TIS AND DEVIATION REQUEST

CONSTITUTION STORAGE DEVELOPMENT

El Paso County, Colorado

PCD Filing No.: PPR-2224

VEHICLE TRACKING PLAN

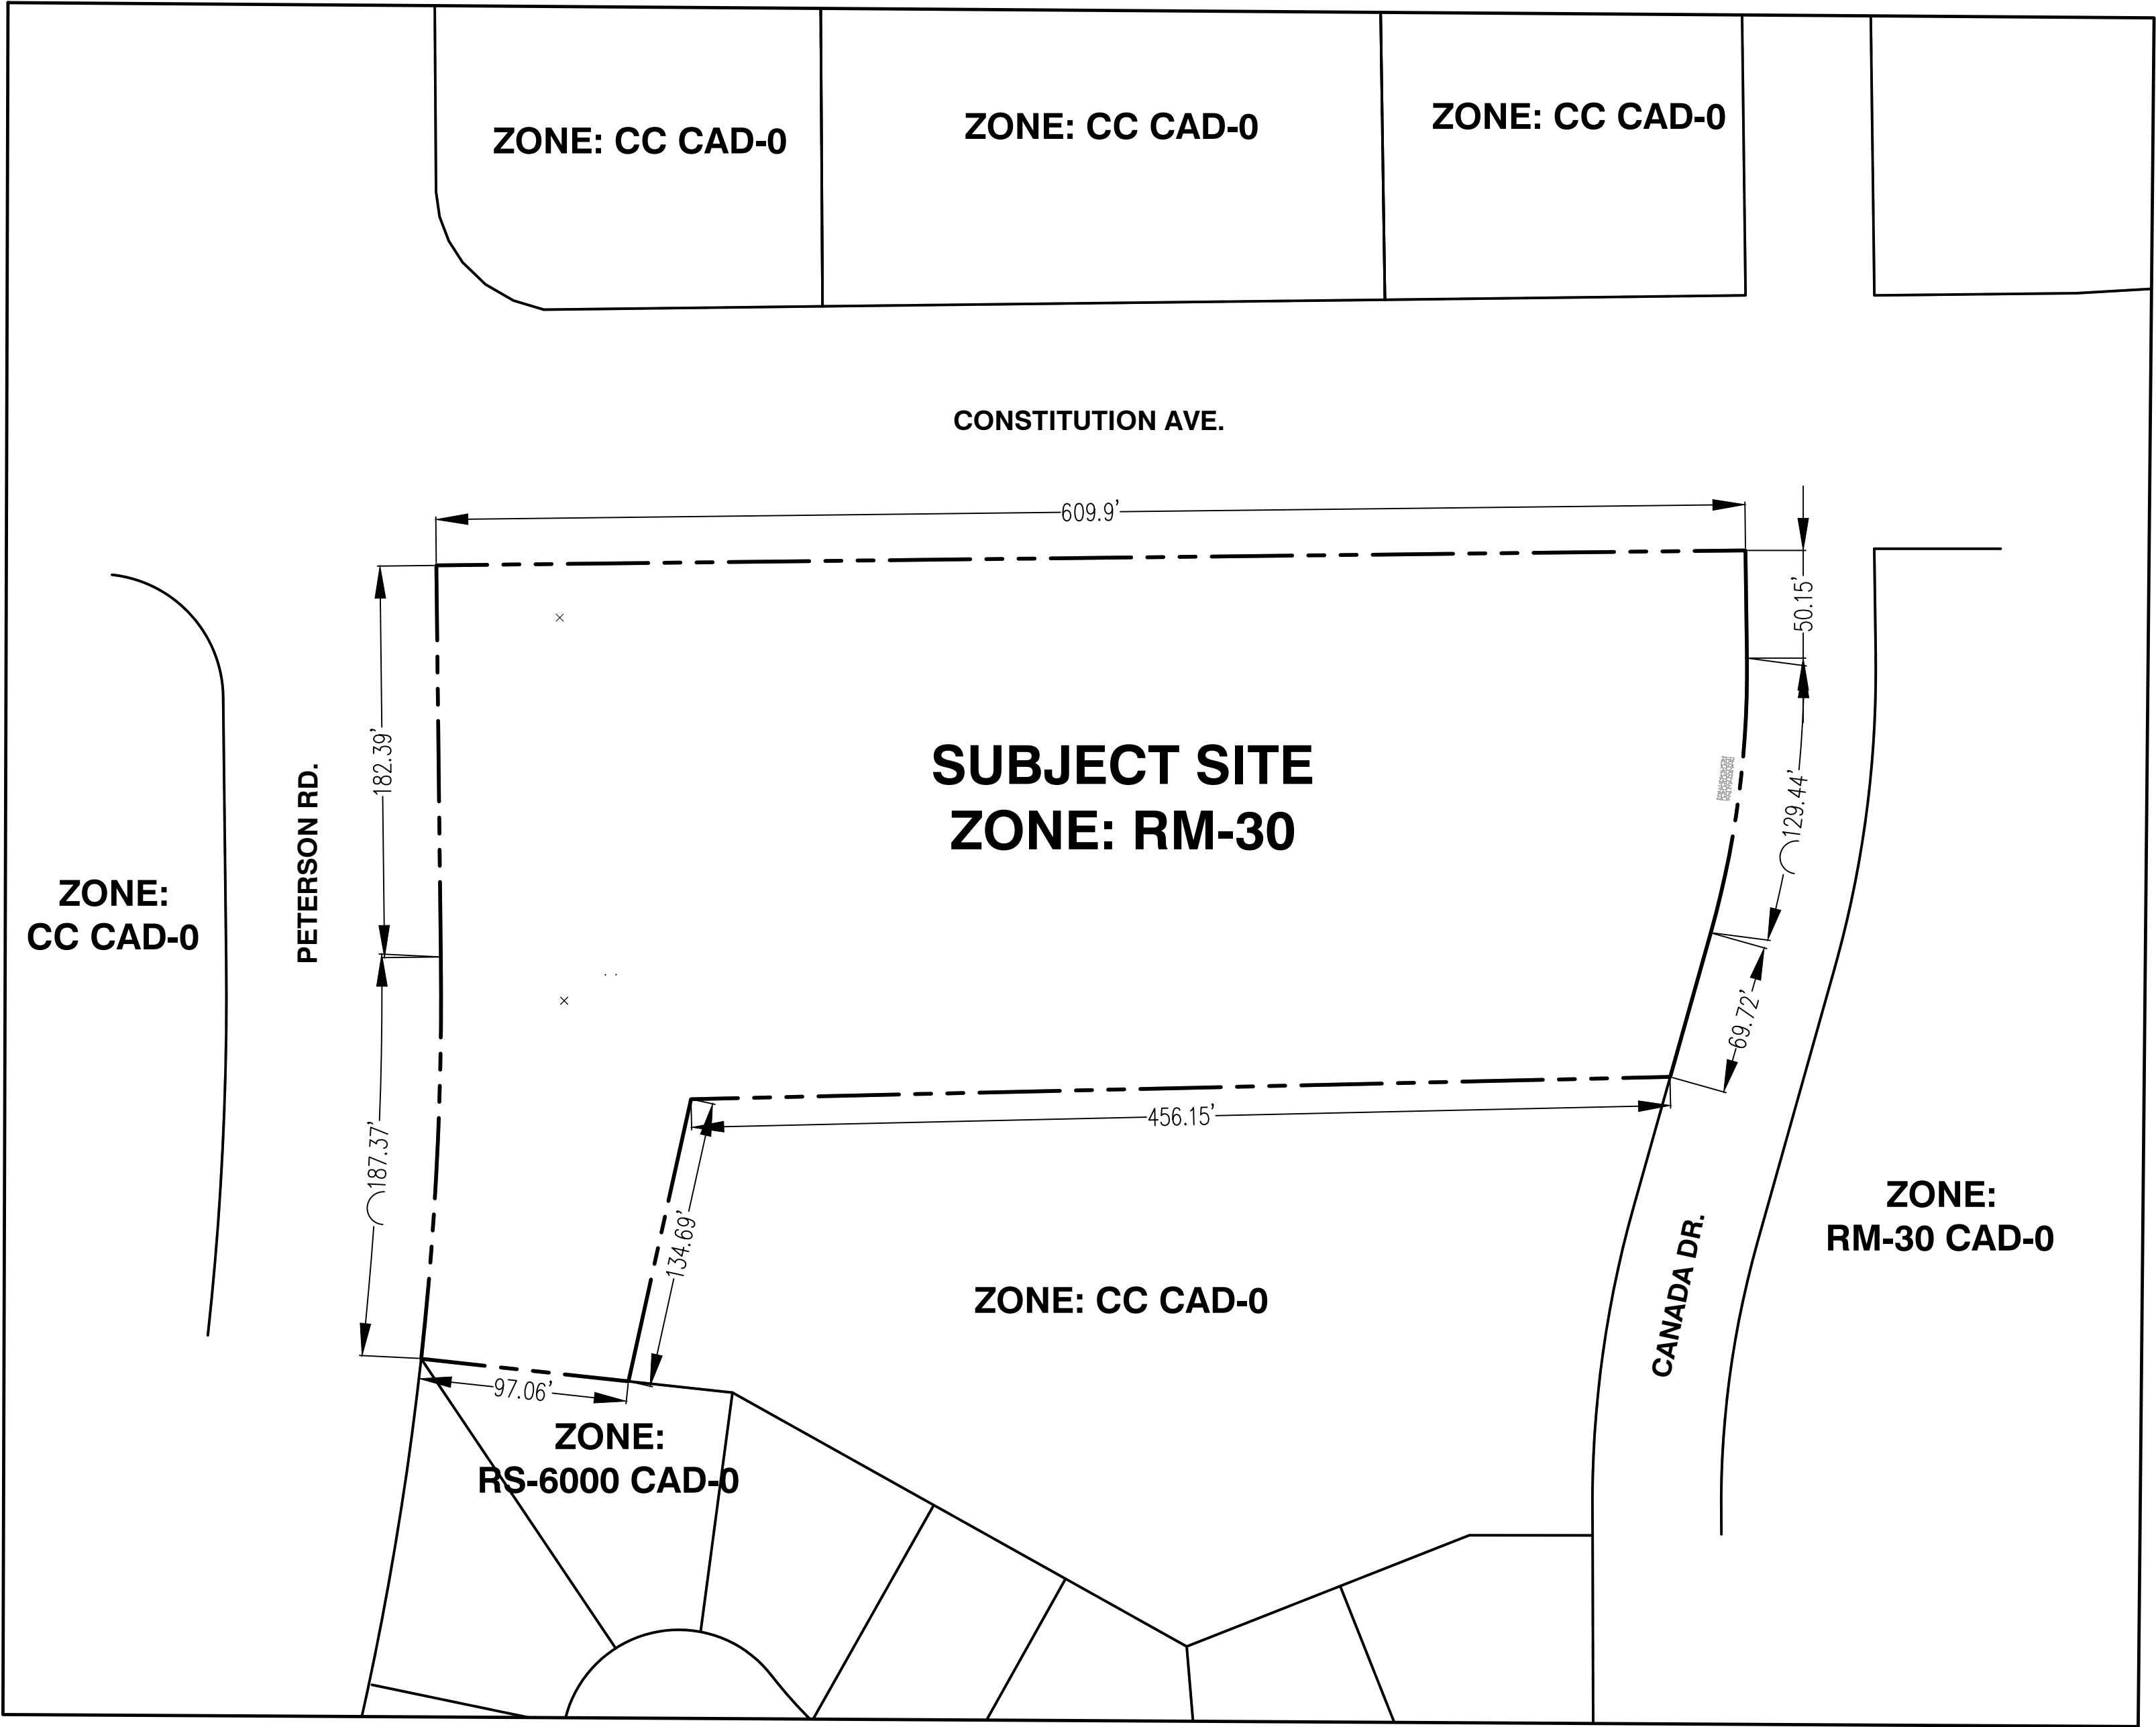
Revise all autium exhibit pages in other plan sets and reports after revisions have been made to this exhibit.

Label what design vehicle this is meant to be. Run autium exhibit to use single unit truck.

Per FGM 2.7.G.SU-30 trucks should be able to stay within their lanes when turning intersections and access points. Revise autium exhibit to show the turn radius of the design vehicles. Make any necessary changes to the parking design so that vehicle meets criteria and stays within lane when turning in and out of the access point.
